# Norwich to Tilbury

**Document: 8.3.65 Signed Statement of Common Ground -  
Southfields Development Group - Tracked Changes Version**

**Planning Inspectorate Reference: EN020027**

# Southfields Development Group

Image 7.1 Interaction between TB259 to TB261, ~~highlighted in pink is the inner consultation zone of the Gas line, highlighted in blue is the outer consultation zone~~ and the Southfields development

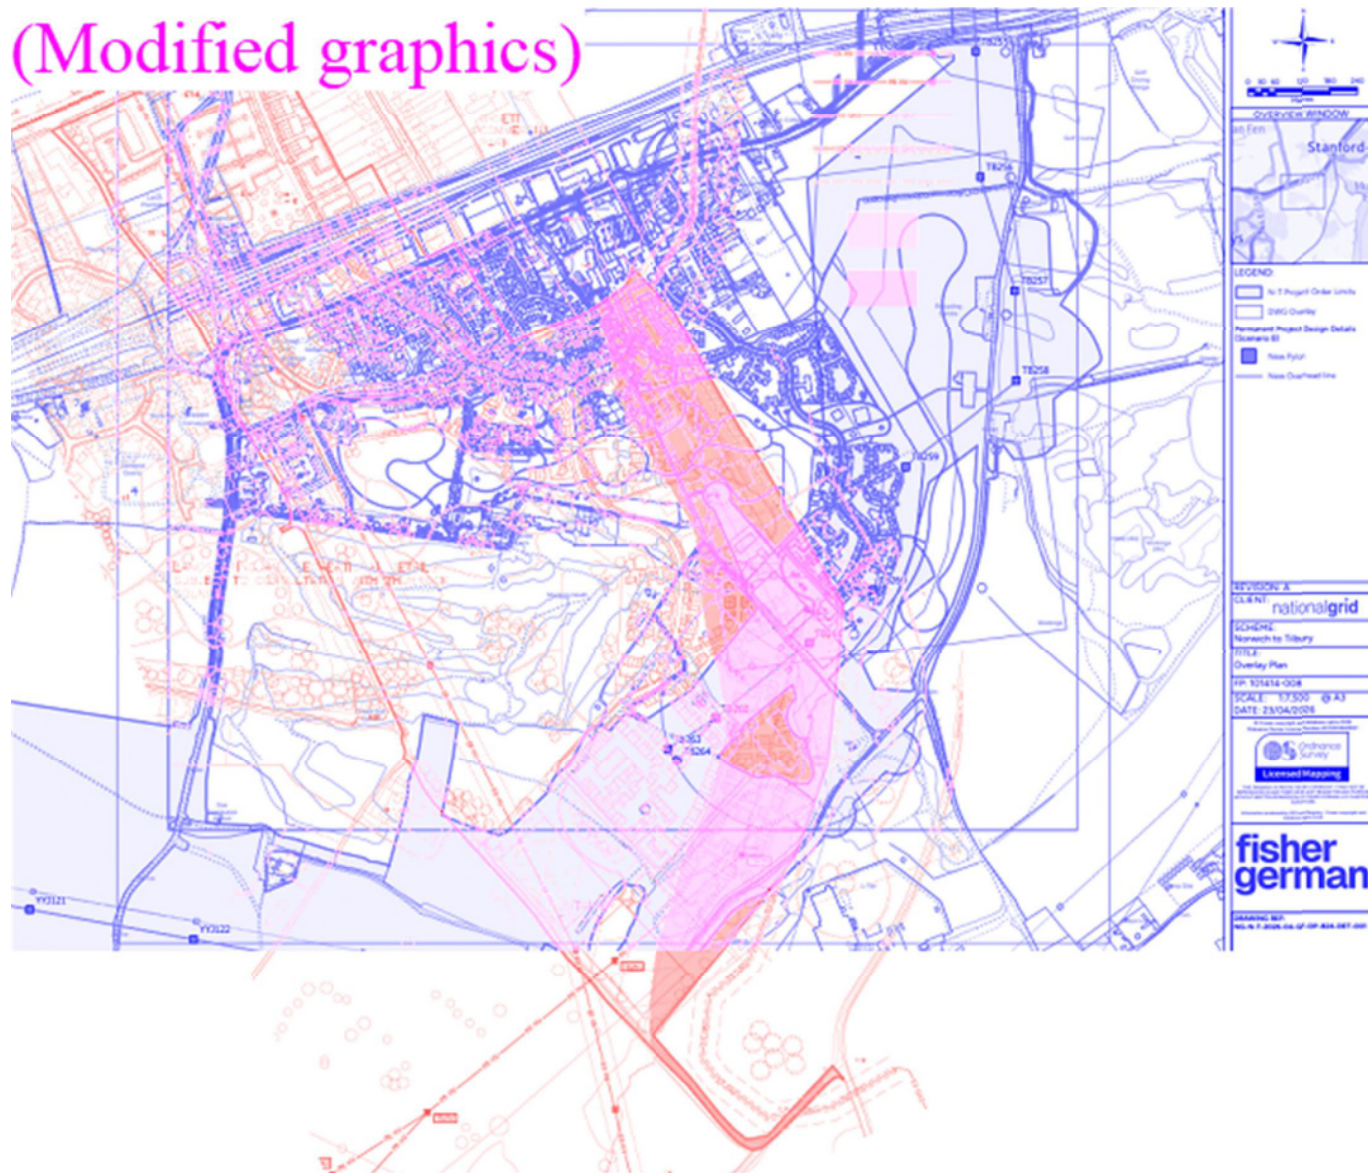
| <u>ID</u> | <u>Issue</u>                                                         | <u>National Grid position</u>                                                                                                                                                                                                                                                                                                                                                                                                                                                                                                                                                                                                                                                                                                                                                                                                                                                                                                                                                                                                                         | <u>Southfields Development Group position</u>                                                                                                                                                                                                                                                                                                                                                                                                                                                                                                                                                                                                                                                                                                                                                                                                                                                                                                                                                                                                                                                                                                                  |
|-----------|----------------------------------------------------------------------|-------------------------------------------------------------------------------------------------------------------------------------------------------------------------------------------------------------------------------------------------------------------------------------------------------------------------------------------------------------------------------------------------------------------------------------------------------------------------------------------------------------------------------------------------------------------------------------------------------------------------------------------------------------------------------------------------------------------------------------------------------------------------------------------------------------------------------------------------------------------------------------------------------------------------------------------------------------------------------------------------------------------------------------------------------|----------------------------------------------------------------------------------------------------------------------------------------------------------------------------------------------------------------------------------------------------------------------------------------------------------------------------------------------------------------------------------------------------------------------------------------------------------------------------------------------------------------------------------------------------------------------------------------------------------------------------------------------------------------------------------------------------------------------------------------------------------------------------------------------------------------------------------------------------------------------------------------------------------------------------------------------------------------------------------------------------------------------------------------------------------------------------------------------------------------------------------------------------------------|
| 9.1       | <u>Pylon-Positions Route alignment, pylon positions and oversail</u> | <p>The Applicant acknowledges Southfields Development Group's concerns regarding the alignment of the proposed overhead line and its potential interaction with the village and wider regeneration proposals.</p> <p>Throughout the design process, the Applicant has sought to identify an alignment that minimises impacts where practicable. In particular, efforts have been made to keep the overhead line as close as possible to the existing gas pipeline corridor, thereby limiting the extent of additional land affected and consolidating infrastructure where feasible.</p> <p>However, there are a number of technical and environmental constraints that limit flexibility in this location. Due to local topography and ground conditions, it has not been possible to route the line across the landfill. These constraints significantly restrict the range of alignment options in this area.</p> <p>With regard to tower position TB261, its location has been determined through detailed engineering design, including span</p> | <p>theThe 'line' presently shown as running across the southern part of the 800 dwelling village site, and the Thurrock Council owned filled refuse tip, which is to the immediate east of the village site, blight the whole of the village site to the point of making the proposed dwellings unsaleable, in addition the agreement for Thurrock Council and National Grid to jointly participate in regeneration of the 80 acre filled tip area would also be prejudiced by the presently proposed positions of two of the new pylons and the proposed pylon line.</p> <p>Prima facie it looks as if the new pylon cable line could continue further south along the east side of Buckingham Hill Road to cross the BHR just to the south of the junction of Holford Road with the Buckingham Hill Road. The latter line would remove the blighting effect upon the proposed village site and the regenerated for recreation purposes Buckingham Hill Road 'Council owned refuse tip, while occupying land which is presently vacant and unlikely to ever be considered for residential development.</p> <p>I cannot see any material difference in the</p> |

| <u>ID</u> | <u>Issue</u> | <u>National Grid position</u>                                                                                                                                                                                                                                                                                                                                                                                                                                                                                                                                                                                                                                                                                                                                                                                                                                                                                                                                                                                                                                                                             | <u>Southfields Development Group position</u>                                                                                                                                                                                                                                                                                                                                                                                                                                                                                                                                                                                                                                                                                                                                                               |
|-----------|--------------|-----------------------------------------------------------------------------------------------------------------------------------------------------------------------------------------------------------------------------------------------------------------------------------------------------------------------------------------------------------------------------------------------------------------------------------------------------------------------------------------------------------------------------------------------------------------------------------------------------------------------------------------------------------------------------------------------------------------------------------------------------------------------------------------------------------------------------------------------------------------------------------------------------------------------------------------------------------------------------------------------------------------------------------------------------------------------------------------------------------|-------------------------------------------------------------------------------------------------------------------------------------------------------------------------------------------------------------------------------------------------------------------------------------------------------------------------------------------------------------------------------------------------------------------------------------------------------------------------------------------------------------------------------------------------------------------------------------------------------------------------------------------------------------------------------------------------------------------------------------------------------------------------------------------------------------|
|           |              | <p>length, safety, and structural requirements. Relocating this tower outside of the refuse tip area is not feasible without exceeding acceptable span distances or necessitating additional infrastructure, which could result in greater overall environmental and visual effects.</p> <p><a href="#"><u>With regards to tower TB259, there are restrictions as to possible relocation due to the presence of a high-pressure gas main to the east of the proposed location.</u></a></p> <p>The Applicant notes the concerns raised in relation to the potential implications for the proposed development and has, to date, sought to take account of emerging master planning where reasonably practicable within the design process. However, given the constraints outlined above, there is limited scope for further modification to the alignment in this area.</p> <p>The Applicant remains committed to ongoing engagement with stakeholders and will continue to consider any reasonable opportunities to reduce effects where practicable <a href="#"><u>through detailed design.</u></a></p> | <p>construction cost to 'Grid of the overhead line as presently indicated, as against moving the 'line' to continue further south along the east side of Buckingham Hill Road. Given the height, substantial nature and position of the pylons and the 'line' as presently proposed, my proposed scheme for the new Southfields Village and a Country Park which will, all being well, include the regenerated refuse tip as referred to above, will not be viable.</p> <p>People do not like living near pylons and overhead lines and the incidence of the proposals as presently indicated, albeit over a very small length of the overall 'line', renders the ten years of work spent upon creating the new 'Village and Country Park, and obtaining local residents support, as completely wasted.</p> |
